**KIRKLEES METROPOLITAN COUNCIL
INVESTMENT & REGENERATION SERVICE**

**DELEGATED DECISION TO DETERMINE APPLICATIONS FOR
CONSENT, AGREEMENT OR APPROVAL REQUIRED BY CONDITION**

Reference No:	2024/44/92857/W
Site Address:	Carters Barn, Hollins Lane, Slaithwaite, Huddersfield, HD7 5JE
Description:	Discharge of details reserved by condition 2 (access and parking) on previous permission 2024/91244 for part change of use of dwelling to convert bedroom into gymnasium to facilitate personal training sessions
Recommending Officer:	Molly Storer

DECISION – DISCHARGE OF CONDITION – REFUSED

Directions and Parking Instructions

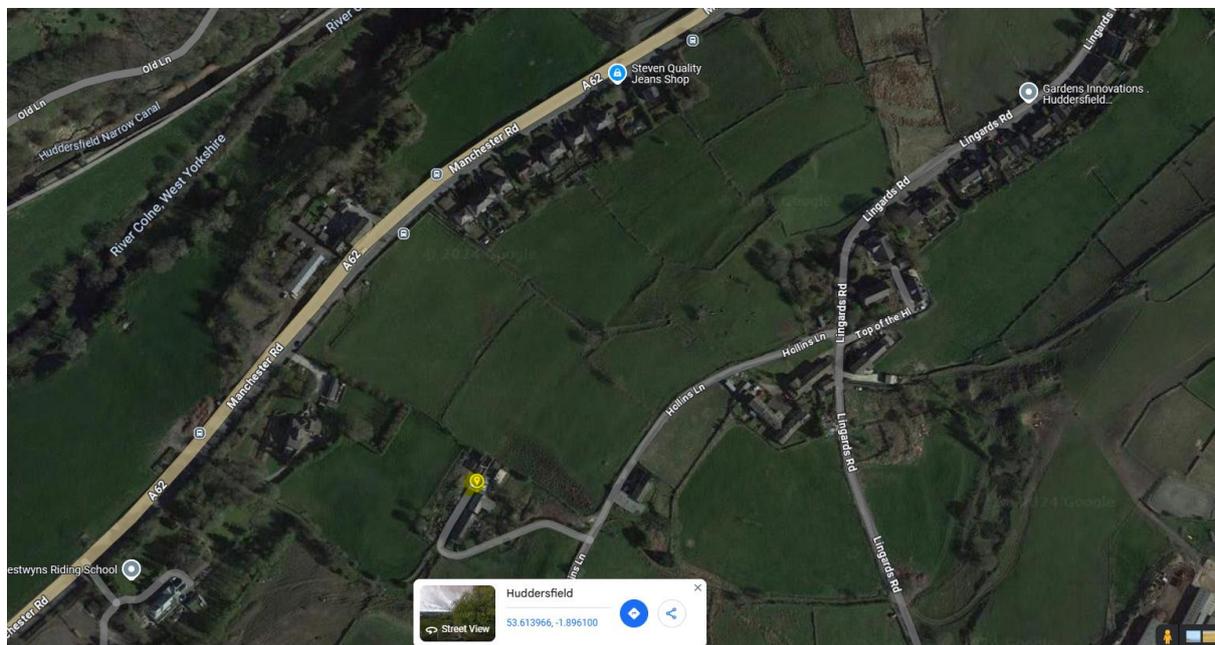
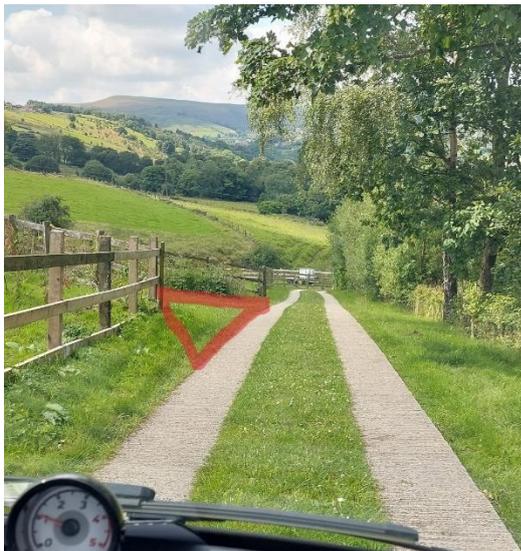
However, plans submitted as part of this application do not show this access to be in place and instead show the main access to still be to the south east and north west of the site. It is considered that this will have a harmful residential impact as previously set out in the officer report and which was the reason for the inclusion of condition no.2 of the permission. Access arrangements previously indicated to be utilised, to the north east of the site and which would have a lesser impact in this regard are considered to be an alternative arrangement which would have an acceptable impact with regard to the reason for condition no.2.

Condition 2 cannot be discharged at this time as the submitted scheme sets out an access to the site located to the south east and north west of the site. The proposed access would have a harmful impact upon residential amenity of neighbouring occupiers contrary to the reason for the condition and in particular as a result of associated noise, nuisance / disturbance within a private domestic area, contrary to policies LP24 and LP52 of the Kirklees Local Plan.
